Historic England

Our ref: P01334150
18 January 2021

**LAND AT FORD ROAD, ARUNDEL, WEST SUSSEX
Application No. AB/135/20/OUT**

The application is for outline planning consent for the development of 90 dwellings and associated amenity at land at Ford Road, Arundel.

Figure 2 Illustrative Masterplan

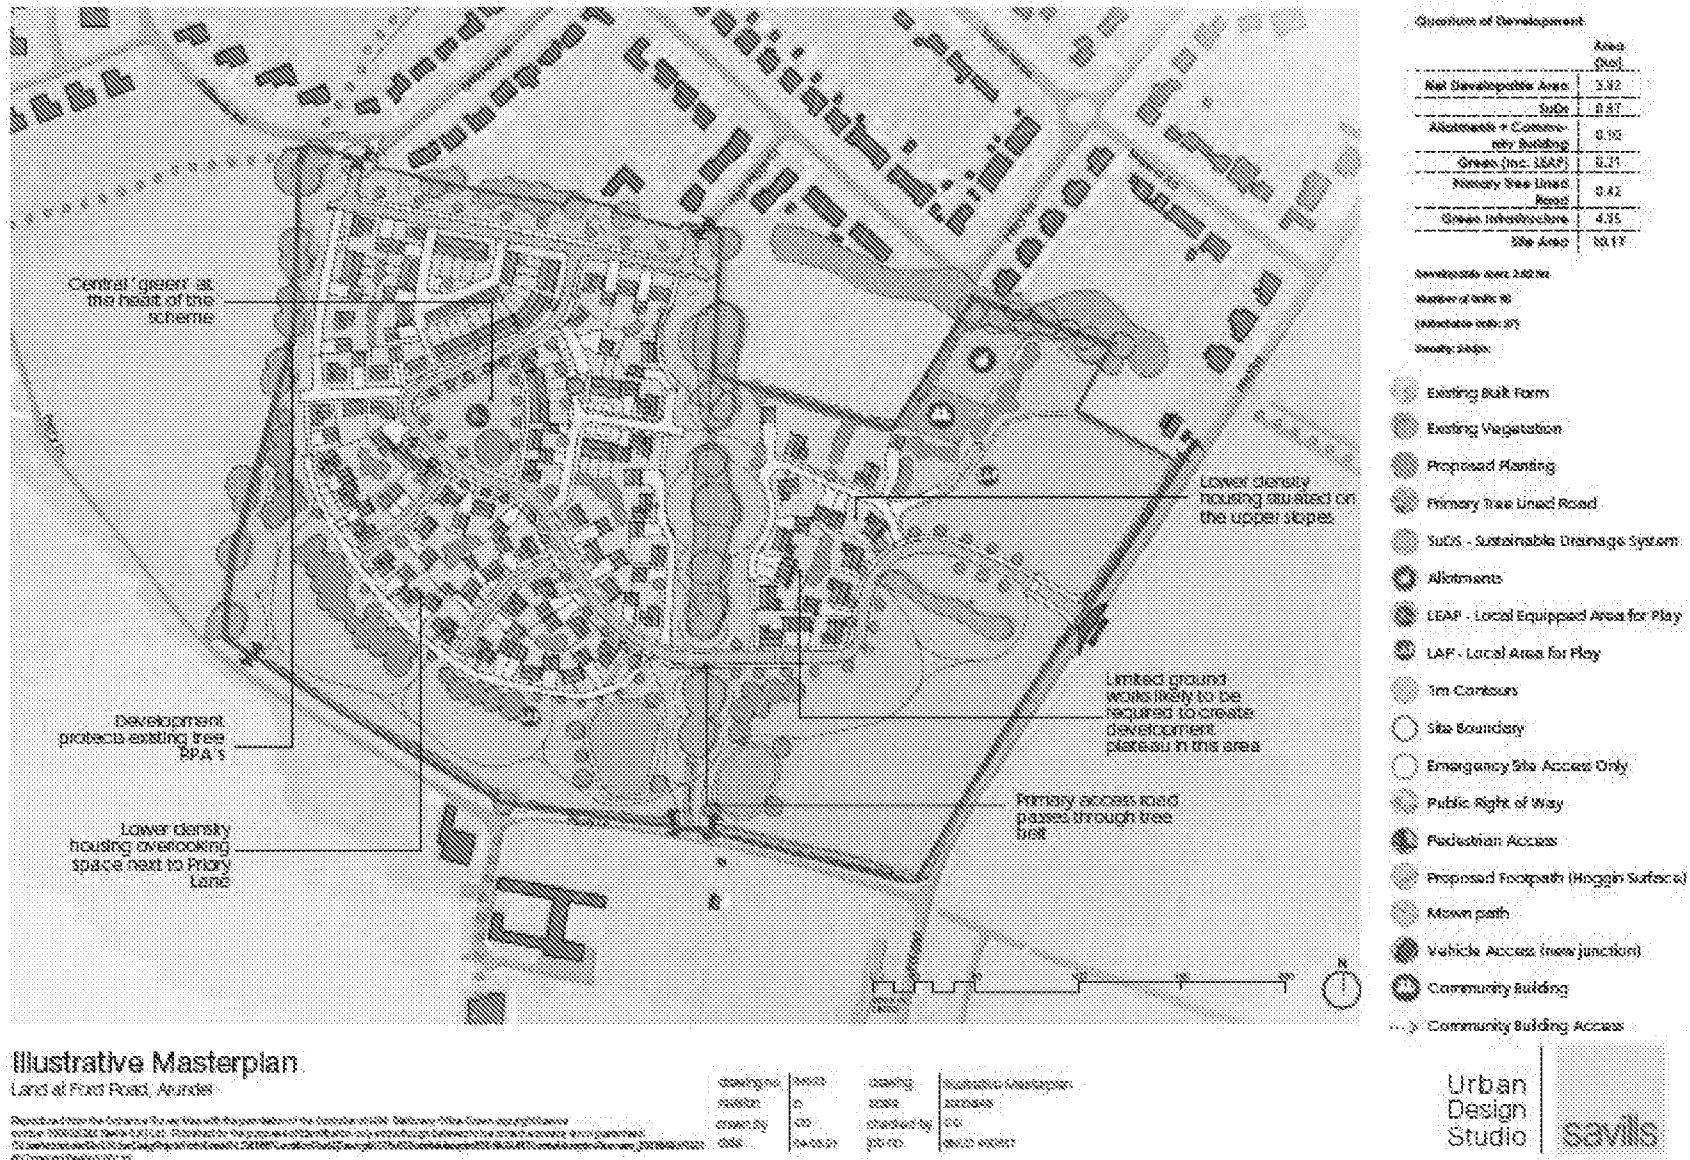
We welcome the Masterplan's proposed use of the land on the south of the proposed site as "a buffer of open and undeveloped land" (Heritage Statement, para. 5.3.2), as this would reduce the degree to which new building would harmfully alter the settings of Tortington Priory and Priory Barn.

It should be noted, however, that change from agricultural land to green amenity space, would still result in a reduction of the degree to which the historic landscape character and setting of the designated heritage assets could be understood and appreciated. This means that there would still be harm arising from the proposals, despite this sensitive design approach.

The application aims to reinforce hedgerow and introduce coppicing along and north of Priory Lane to screen the proposed development from the former priory. The effectiveness or appropriateness of this approach should be considered with great care. Screening the views to hide the built form of the proposed development would also harm the designated heritage assets by removing the view of the agricultural land to the north. In addition, vegetation planting would not effectively screen those views, as a line of trees or hedgerow still affords glimpsed views, and filtered views such as those proposed are seasonally variable in effectiveness. In winter, the view of the built form is likely to be present.

Sufficiently identifying the significance of assets, and using this to evolve the Masterplan, is critical to providing a strong basis for design decisions. This is particularly relevant in light of the NPPF (para. 189) requiring an applicant to describe the significance of any assets affected, and (paras. 184 and 193) to conserve heritage assets in a manner appropriate to their significance.

The Masterplan should not be agreed until the heritage significance of the site and its

capacity to absorb change is well understood. Once the work described above has been carried out, the Masterplan should be reconsidered to identify ways in which careful design could improve the outcome for the historic environment.

The applicant should seek to reduce the harm to archaeological remains through careful placement of buildings, services and other sub-surface intrusions. Design solutions should be sought to minimise truncation of significant buried archaeological remains (for example by including important remains in areas of public open space) and harmful alteration to the settings of heritage assets.
